Comment for planning application 22/03049/OUT

Application Number	<input type="text" value="22/03049/OUT"/>
Location	<input type="text" value="Land West Of Oxford Close And North Of Corner Farm Station Road Kirtlington"/>
Proposal	<input type="text" value="Provision of eight single-storey and two-storey detached and semi-detached dwellings with access, parking and amenity space"/>
Case Officer	<input type="text" value="Rebekah Morgan"/>

SCALE: 1:500	DATE: 02.09.22	DRAWN: TW	CHECKED: DF	APPROVED: DF
JOB NO: 2207-015	DRAWING NO: VS01	REVISION: A

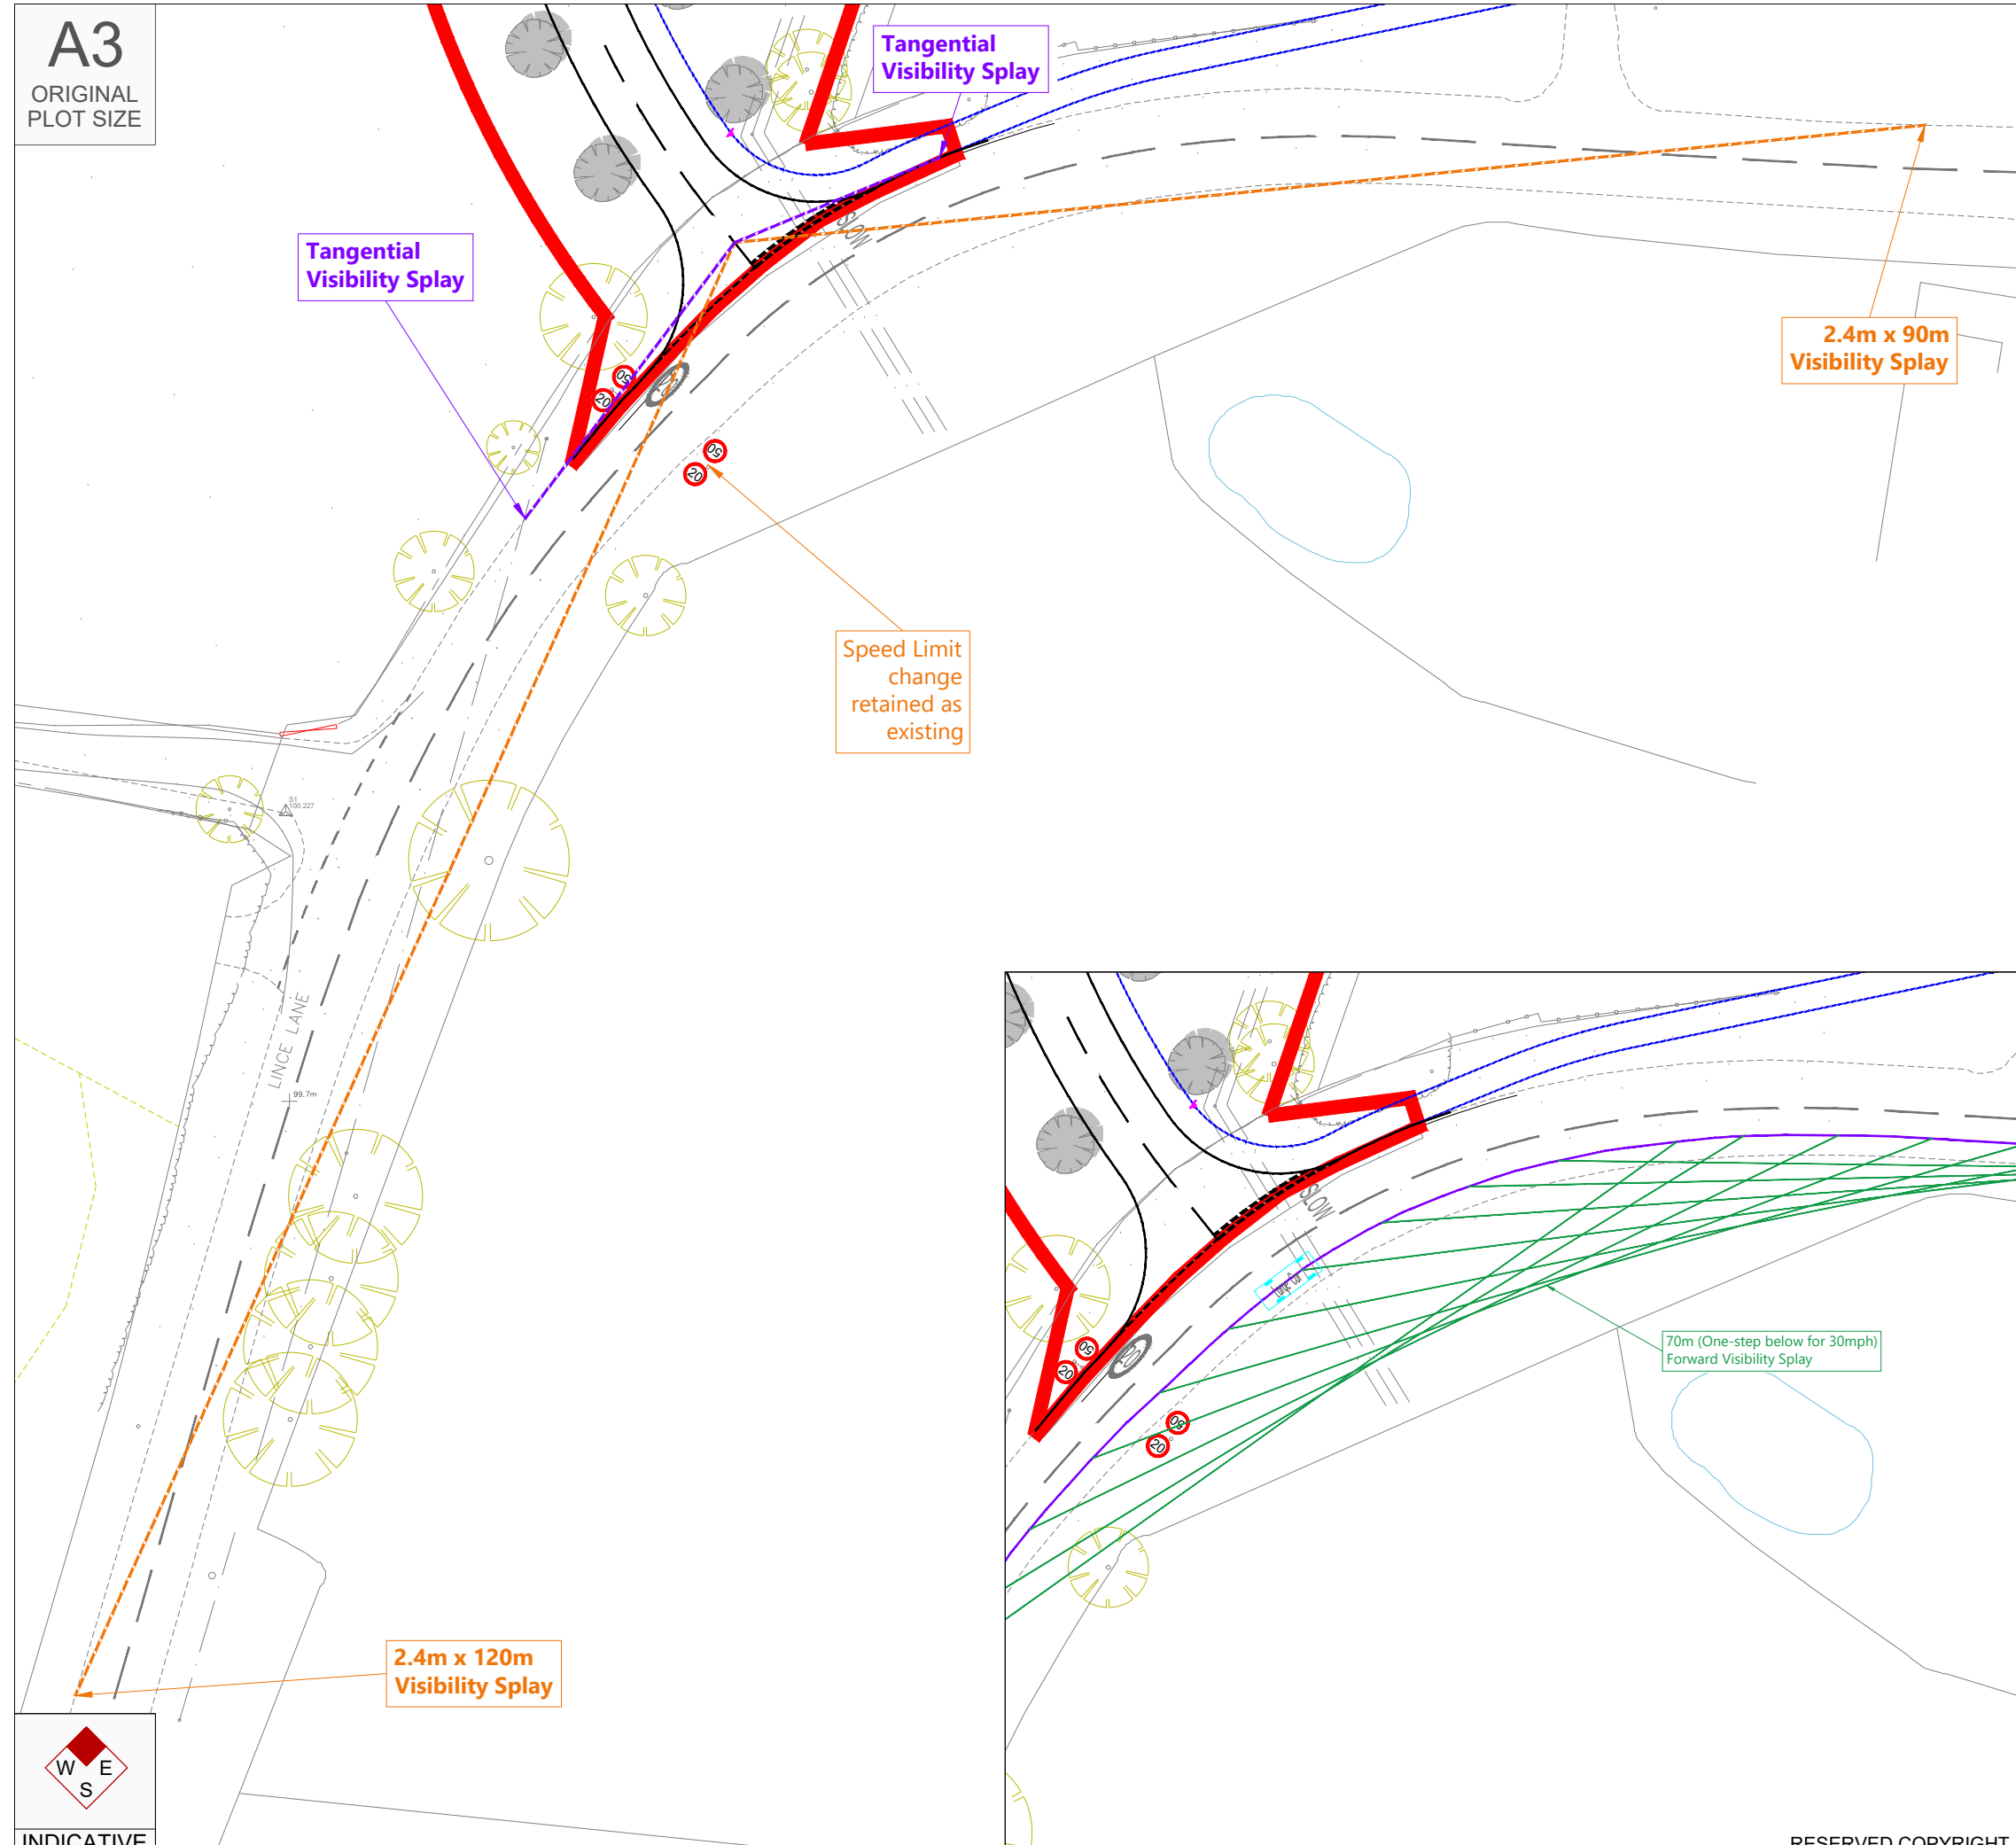
Comments	<p>Local knowledge of this location should be taken into account. The proposed entrance is located on a dangerous corner, with limited visibility due to the bend, and undulations to the road. There have been two known serious accidents in 2009 and 2014 in this location. When approaching the site entrance from Kirtlington, traffic will need to cross oncoming traffic on a blind corner, at a location where cars are slowing down from 50 to 30 when entering the village. It is simply a dangerous proposed entrance. See attached photograph.</p> <p>The site is located outside the built up limits of Kirtlington which will significantly damage the rural setting of the village, and therefore is contrary to policy designed to protect local character.</p> <p>Furthermore, the site lies outside the settlement area of Kirtlington as set out in the Mid Cherwell Neighbourhood Plan 2018-2031. The development does not trigger the need to provide affordable housing and instead provision of 8 2-5 bedroom houses. It is not therefore an economic sustainable development. There is no local bus through Kirtlington from the end of this year, and so all houses are likely to require cars, which will cause a negative sustainable impact on the environment.</p> <p>The layout of the development gives rise to concern that this could be part of phase 1, with more applications due in the future for the opposite side of the access road, thereby developing the site by scope creep and avoiding the need for affordable housing.</p>
